Subject: 2023/91116 Land off Primrose Lane, Hightown, Liversedge, WF15

Having reviewed the latest information and plans from the applicants for this scheme. I am pleased to say many of my previous comments dated 18th May 2023 have been addressed.

Richard Thornton MSyI
Designing Out Crime Officer

PRIMROSE LANE
 PROPOSED SITE LAYOUT

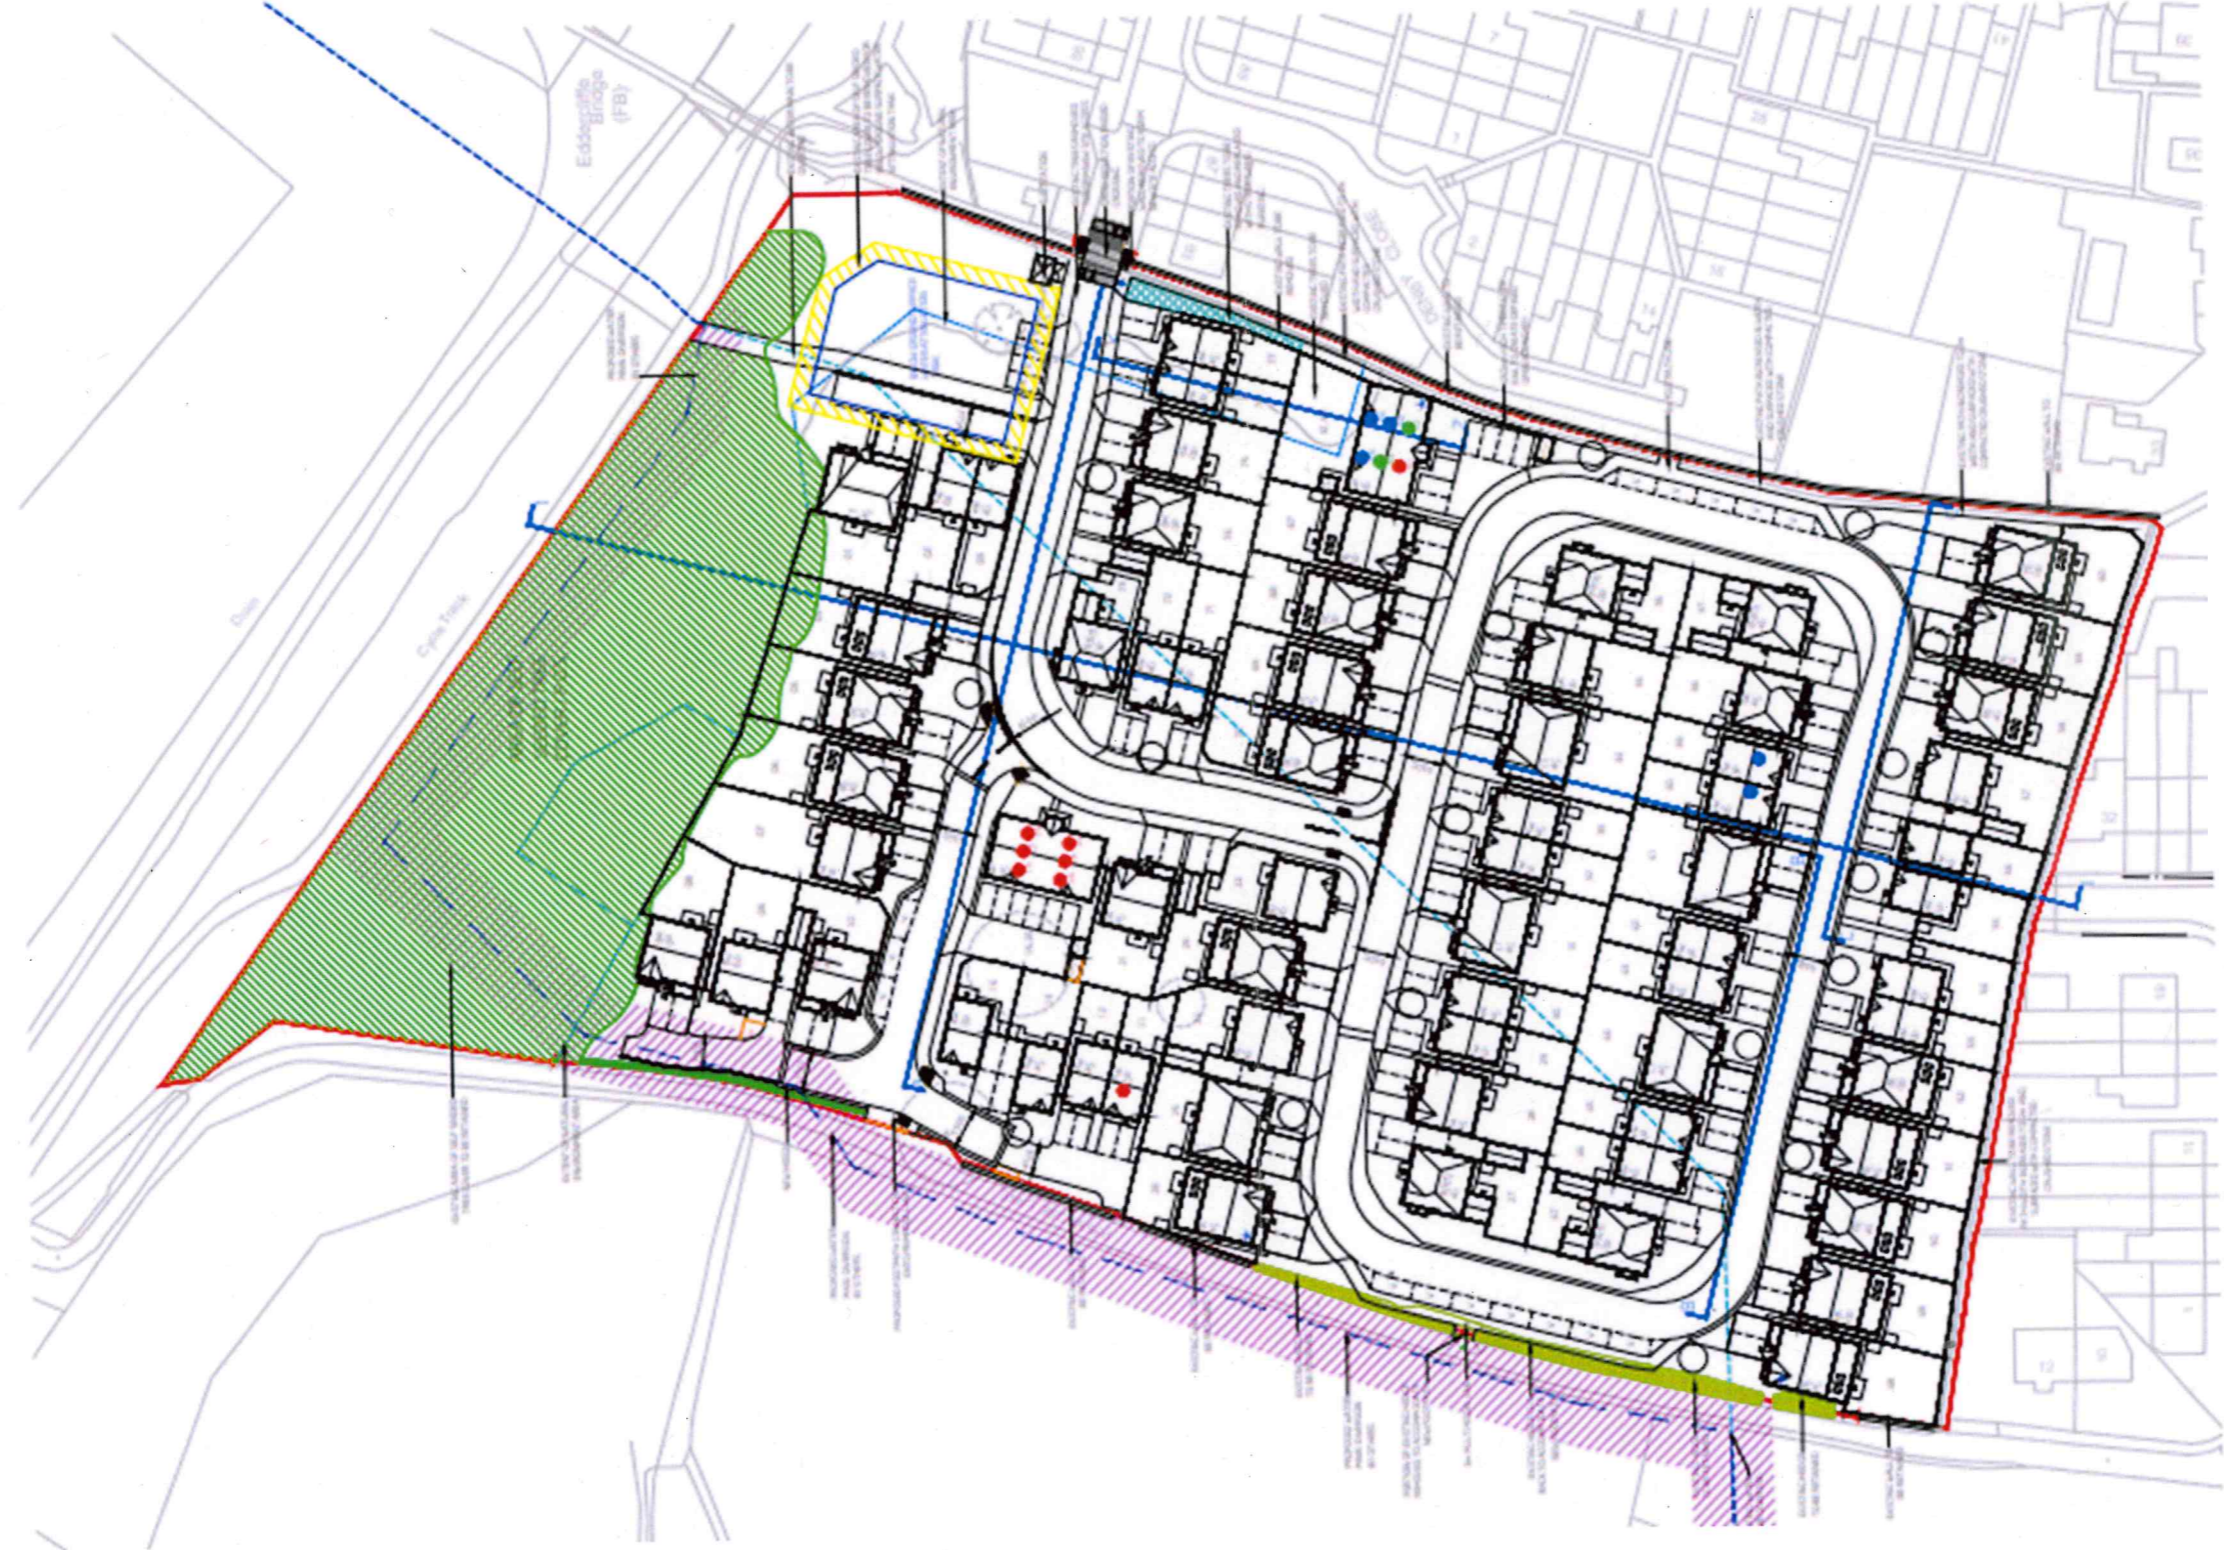
I would however like to still request a Lux Lighting Plan for this site. This **MUST** cover the adopted streets, un-adopted private drives and also the connecting footpaths and visitor vehicle parking spaces.

As previously stated, Bollard Lighting is **NOT supported** for the security of the site and residents and vehicles.
